AKD/KT
14487
18 May 2016

**SECTION 96(1A) - MODIFICATION APPLICATION TO SSD 6840
ST VINCENT'S PRIVATE HOSPITAL SYDNEY**

On behalf of St Vincent's Private Hospital Sydney (SVPHS), we hereby submit an application pursuant to section 96(1A) of the *Environmental Planning and Assessment Act, 1979* (EP&A Act) to modify Development Consent SSD 6840 relating to the approval of the East Wing building and the SVPHS high-rise building located within the St Vincent's Hospital campus (the site).

Drawing Level Region  
DA-03-005 LXX EW  
EAST WING - EAST ELEVATION

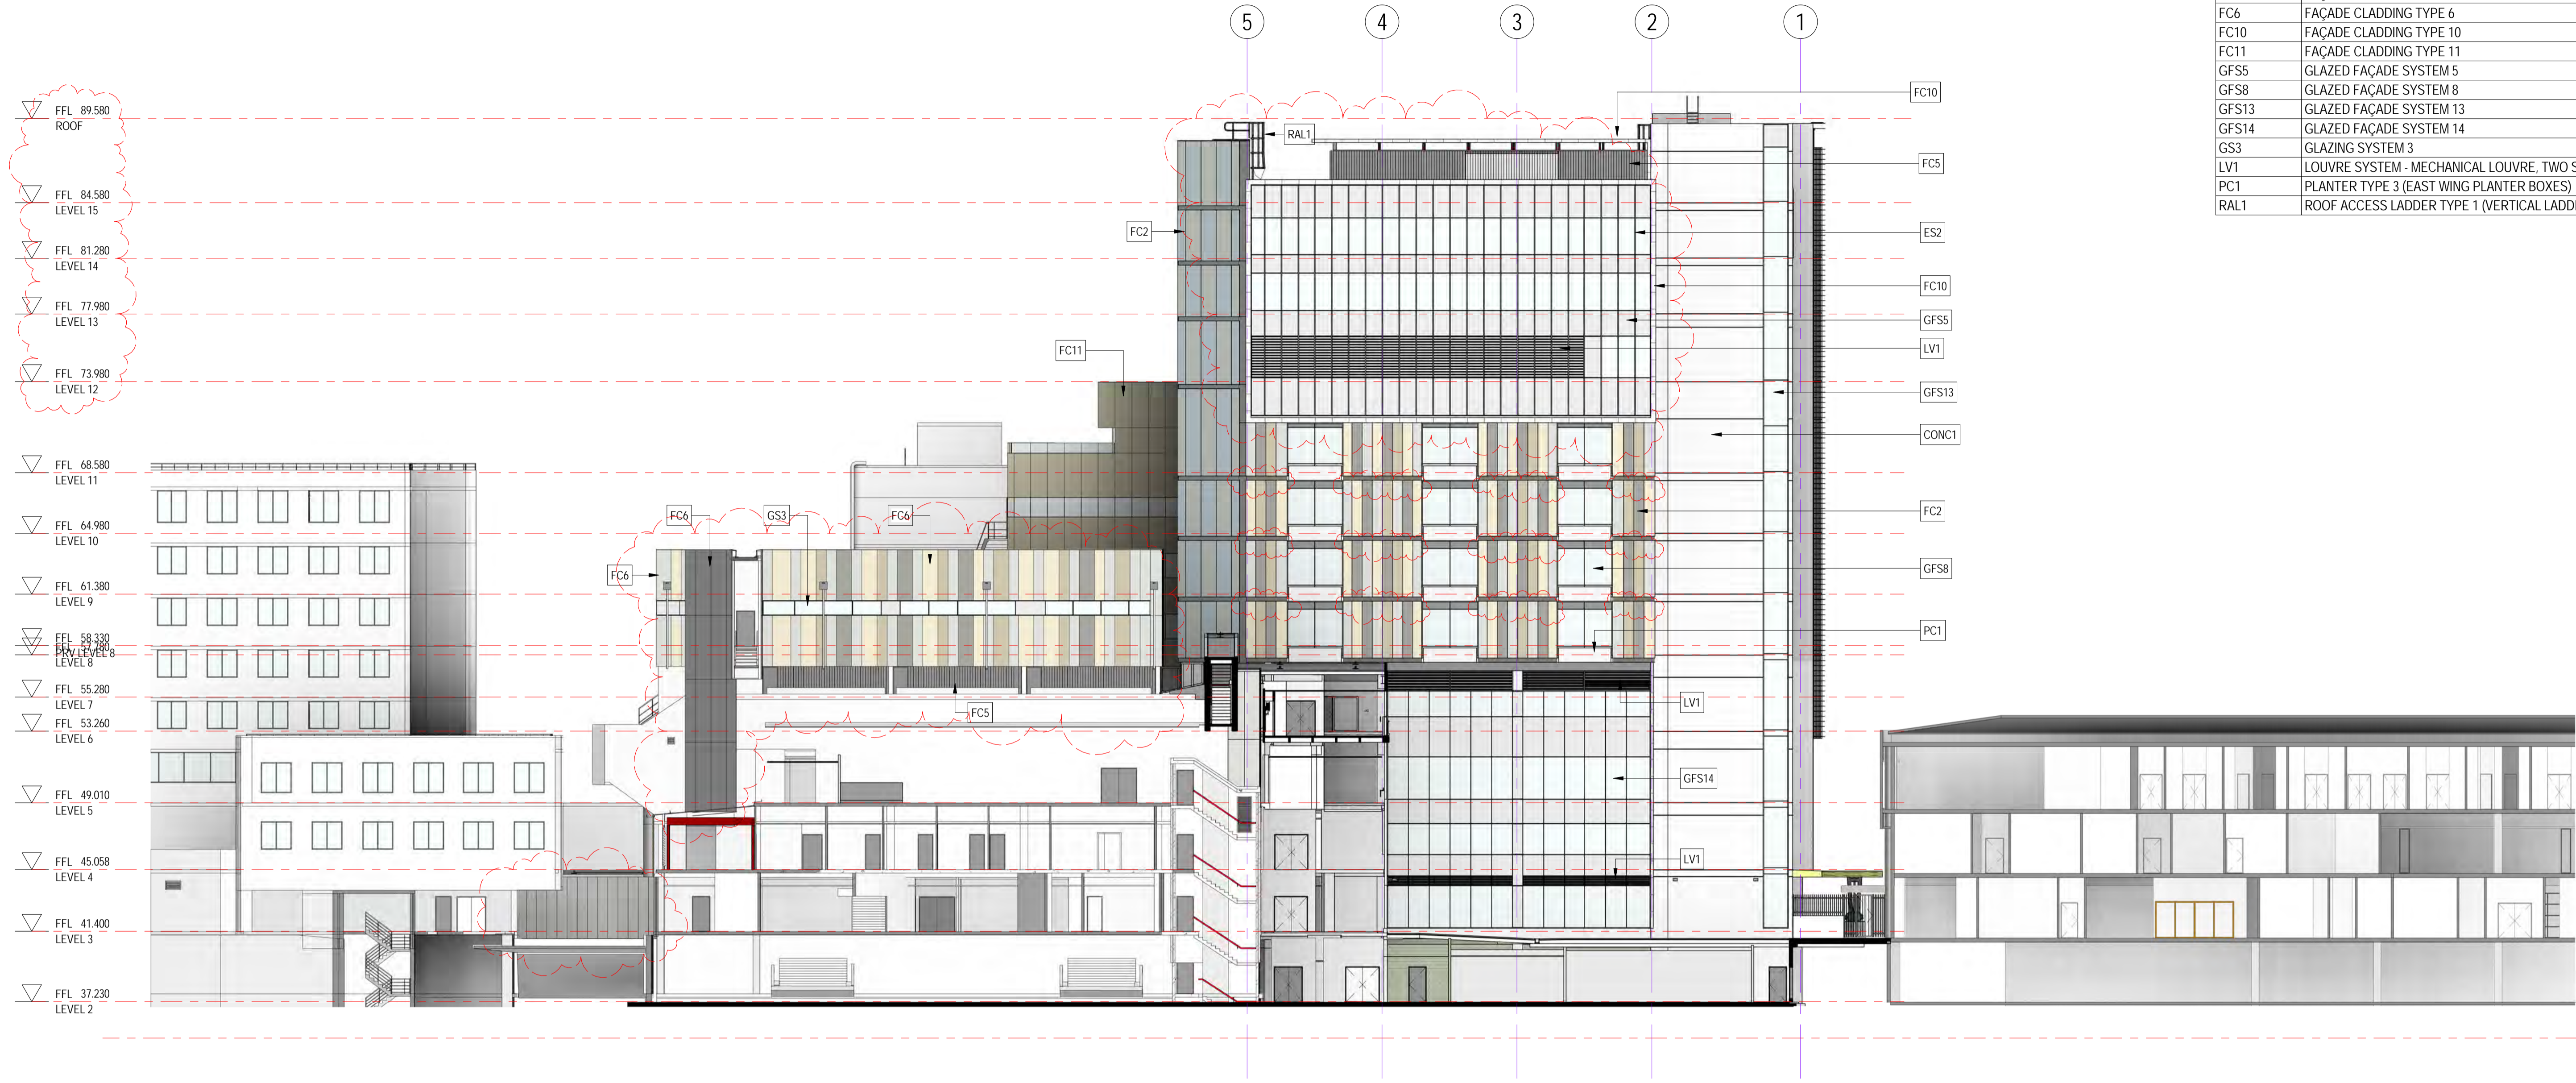
East Wing – North Elevation	<ul style="list-style-type: none"> ▪ Inclusion of additional business identification signage; ▪ Lift shaft height modified; ▪ Amendments to the awning; and ▪ Minor amendments to the materiality of the building. 	DA-03-003	E
East Wing – South Elevation	<ul style="list-style-type: none"> ▪ Amendments to the vertical shading design on the East Wing building to increase the extent of the glazing; ▪ Realignment of the spandrel panel to reflect the inclusion of a split level on Level 12; and ▪ Increase in the extent of stair 5. 	DA-03-004	F
East Wing – East Elevation	<ul style="list-style-type: none"> ▪ Increases and reductions to the floor to floor levels to accommodate the previously approved hydrotherapy pool and split level; ▪ Deletion of the high level windows to the East Wing building; and ▪ Realignment of the spandrel panel to reflect the inclusion of a split level on Level 12. 	DA-03-005	E

The introduction of a split level on Level 12 of the East Wing building necessitates updates to the external façade comprising an increase to the extent of the spandrel panels on the east, south and west elevations. Further, the vertical sun shading devices on the East Wing building have been revised to allow for improved access to views.

GA SECTION. EAST-WEST

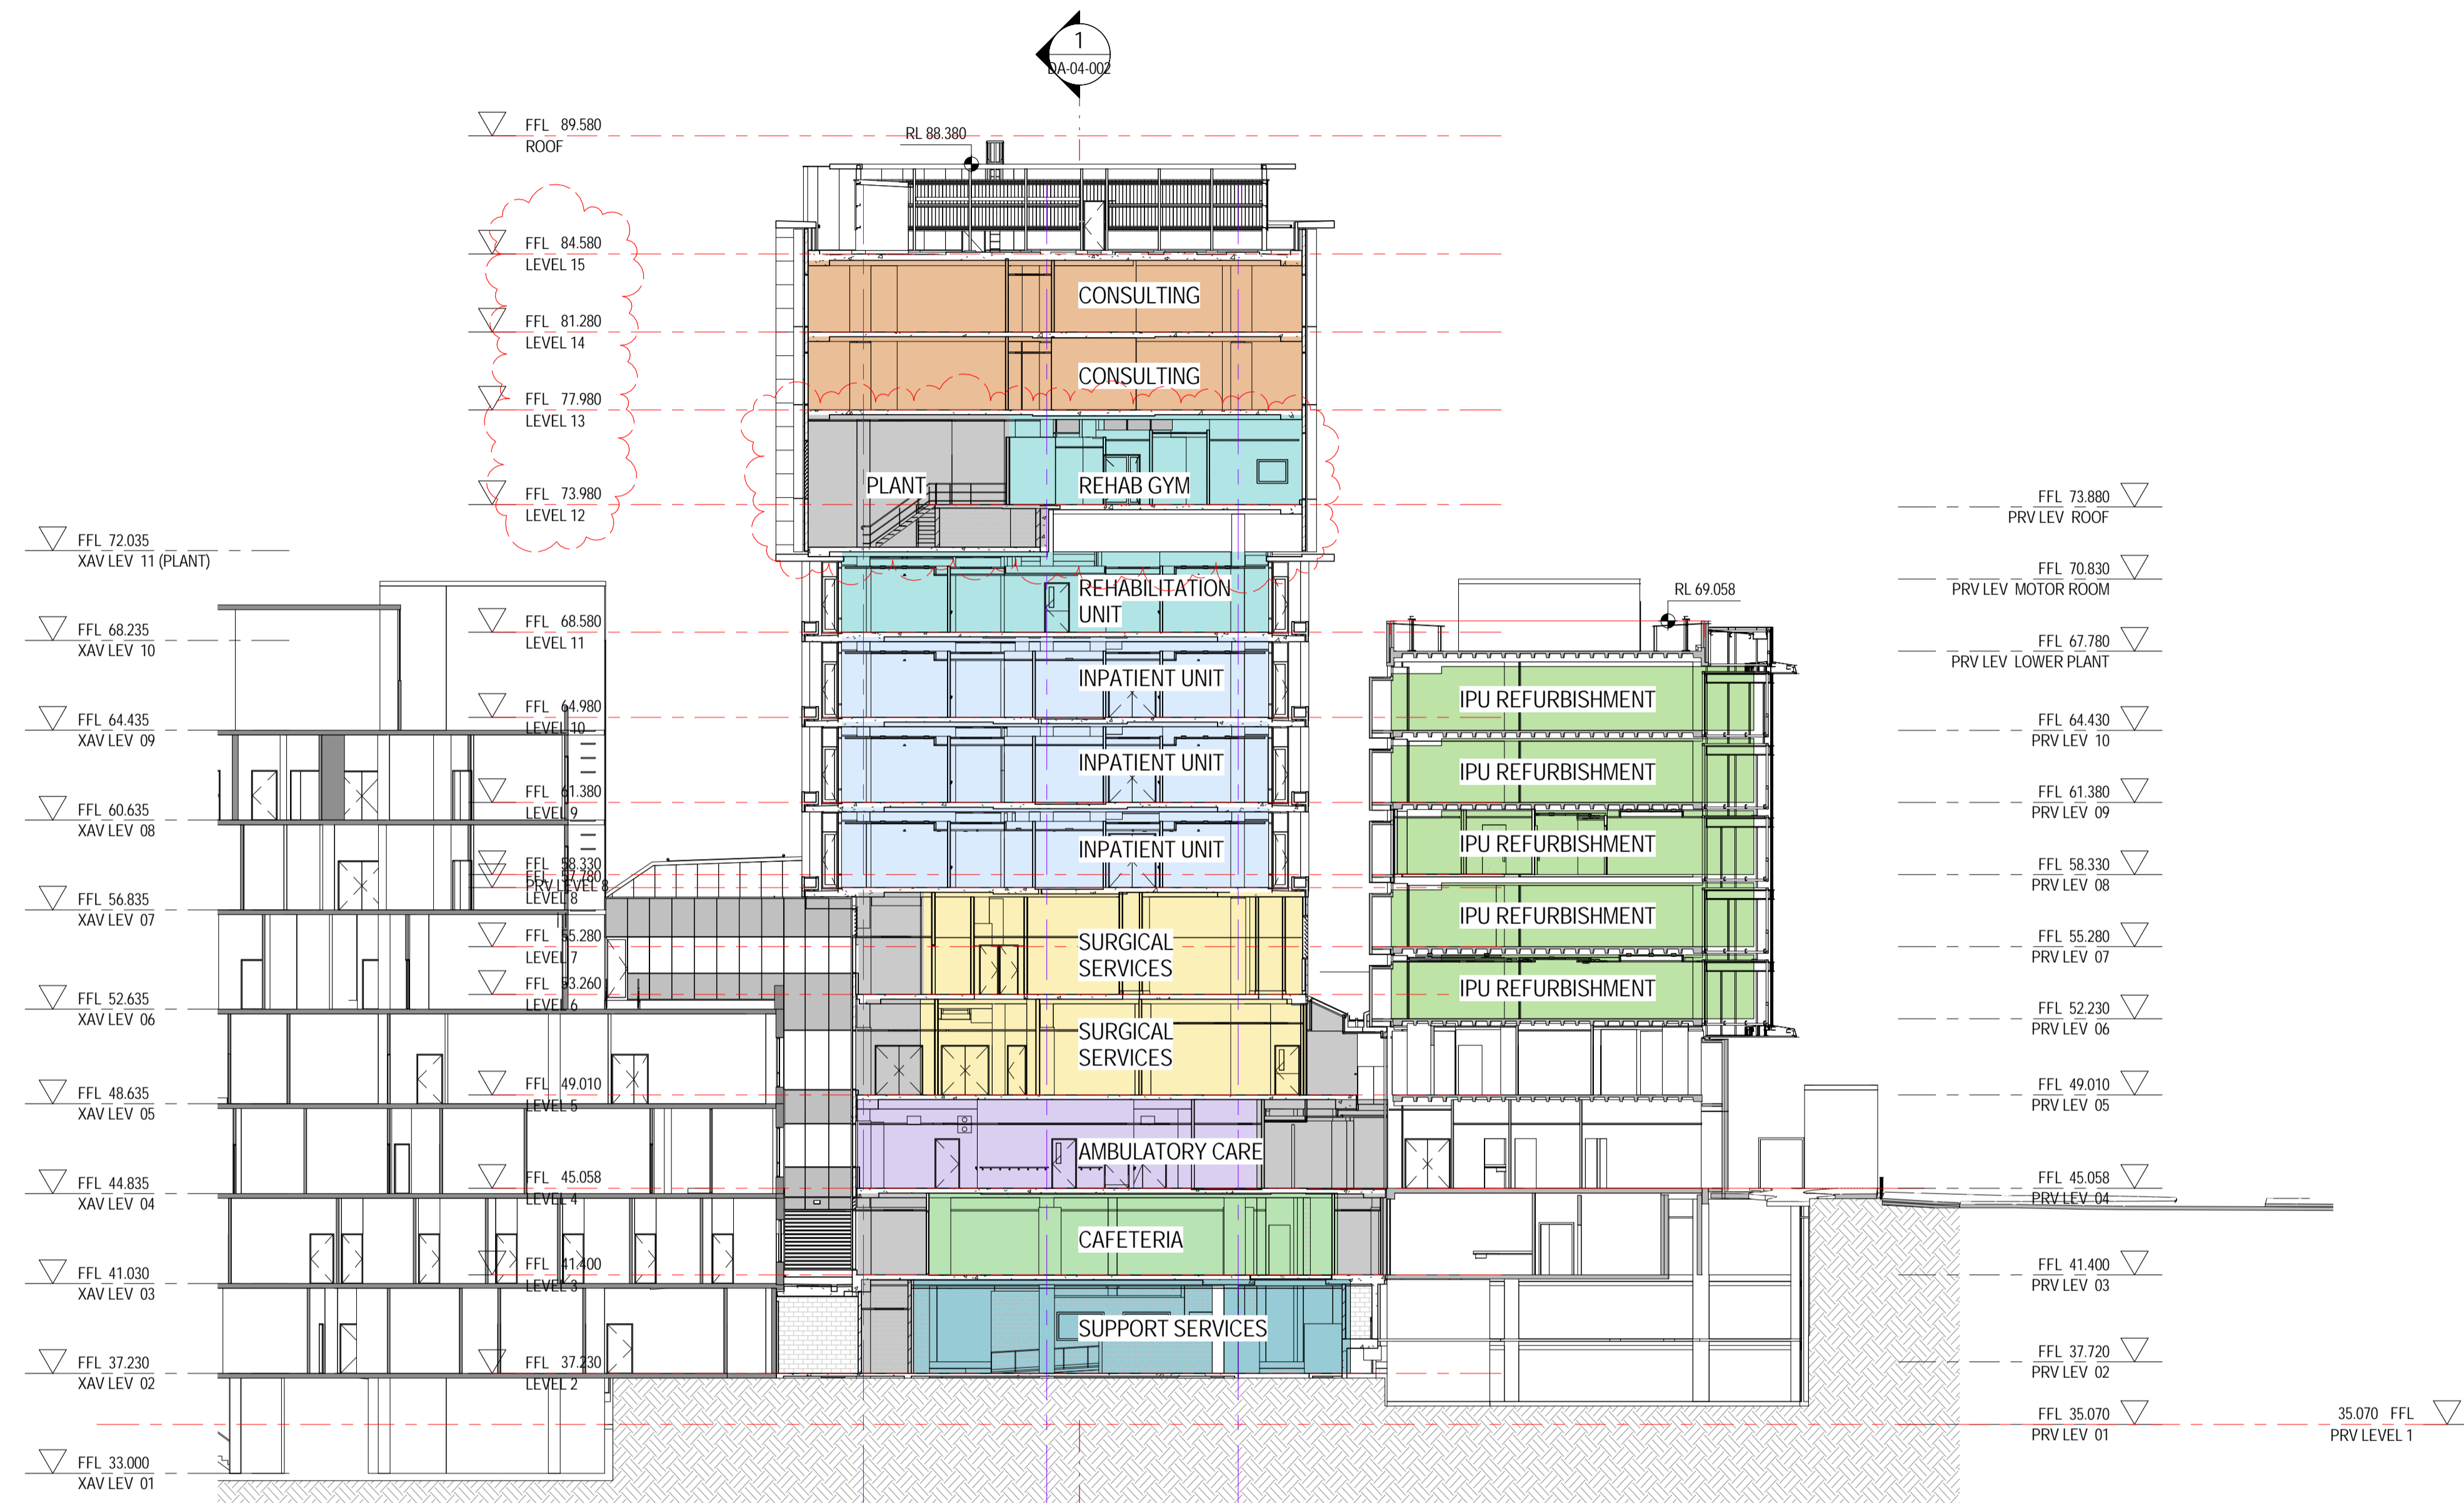
GA Section East West	<ul style="list-style-type: none"> ▪ Inclusion of a split level on Level 12; and ▪ Increases and reductions to the floor to floor levels to accommodate the previously approved hydrotherapy pool and inclusion of a split level on Level 12. 	DA-04-001	E

Amendments to the floor to floor heights are required to accommodate the aforementioned split level on Level 12 and the previously approved hydrotherapy pool. Whilst increases to the floor to floor heights are proposed on Level 12, those on Levels 14 and 15 have been reduced to maintain consistency with the building's approved height. The proposed changes are illustrated below in **Figure 2** and are detailed in **Table 2**.

Drawing  
DA-04-002  
Level  
LXX  
Region  
EW  
GA SECTION. NORTH-SOUTH

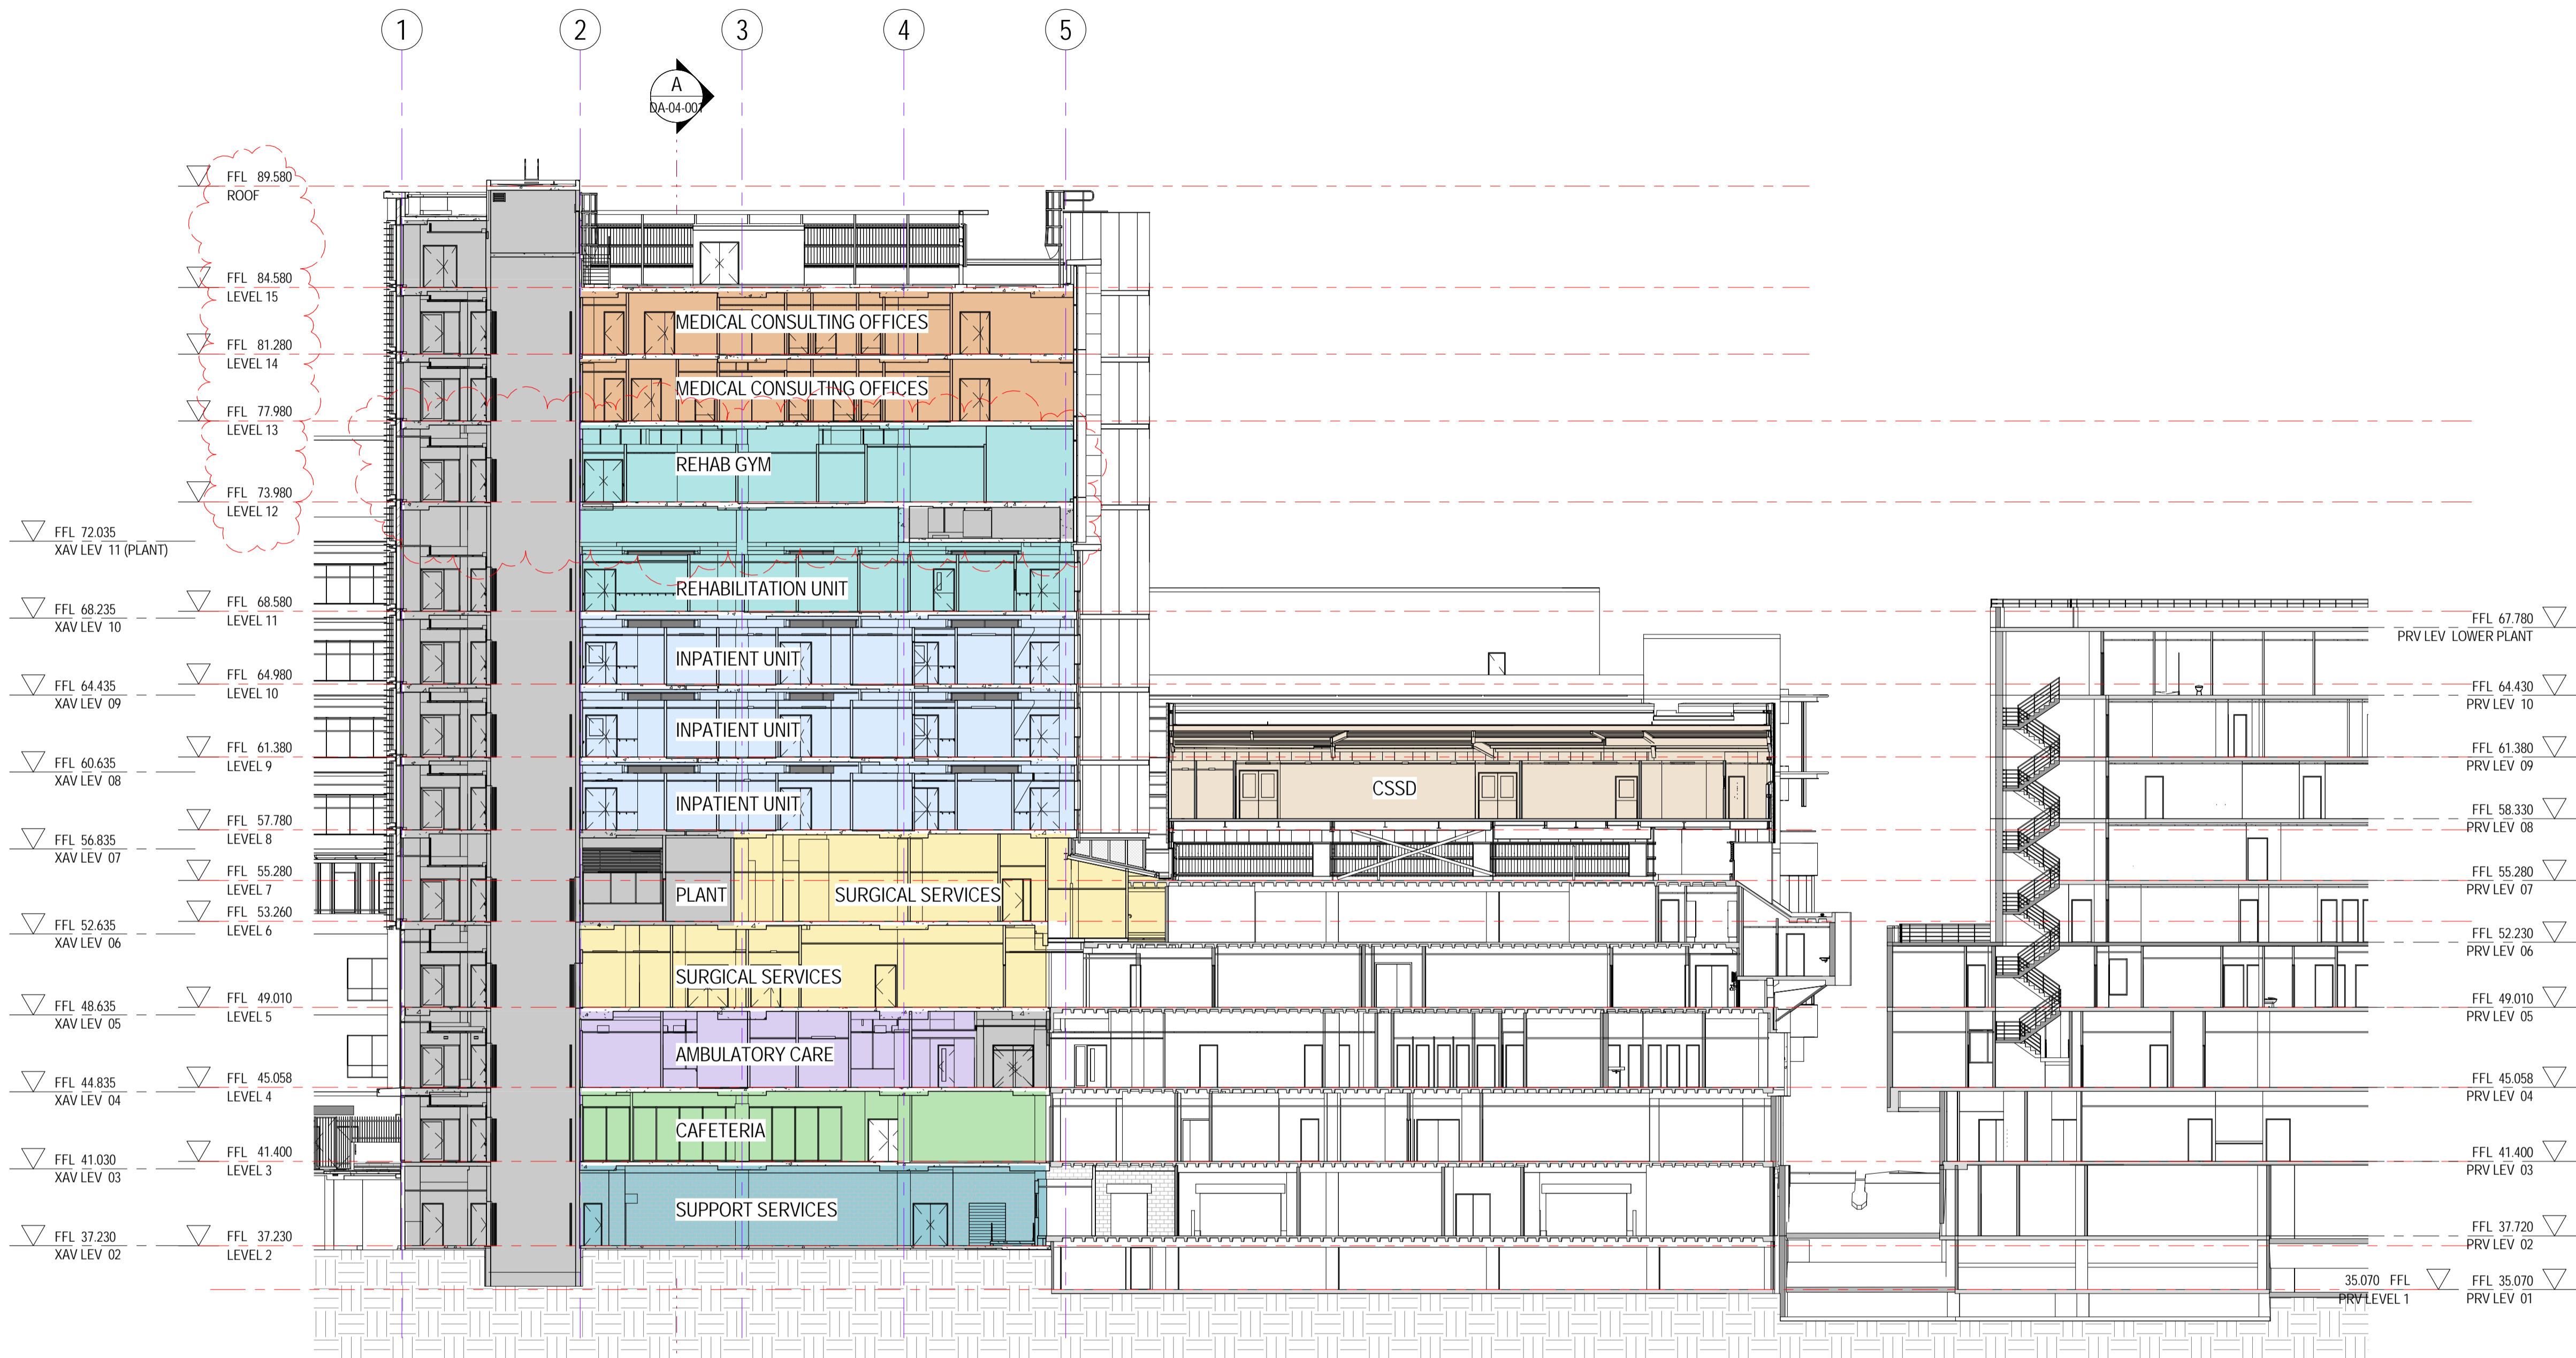
Level	Description of Proposed Modification	Drawing No.	Revision
GA Section North South	<ul style="list-style-type: none"> ■ Inclusion of a split level on Level 12; and ■ Increases and reductions to the floor to floor levels to accommodate the previously approved hydrotherapy pool and inclusion of a split level on Level 12. 	DA-04-002	E

Further, a slight amendment is proposed to the building height where the lift overrun is located on the north eastern section of the East Wing building. The amendment results in a decrease in the building height from 48.48m (RL 89.880) to 48.18m (RL 89.580), resulting in a 300mm reduction in height.
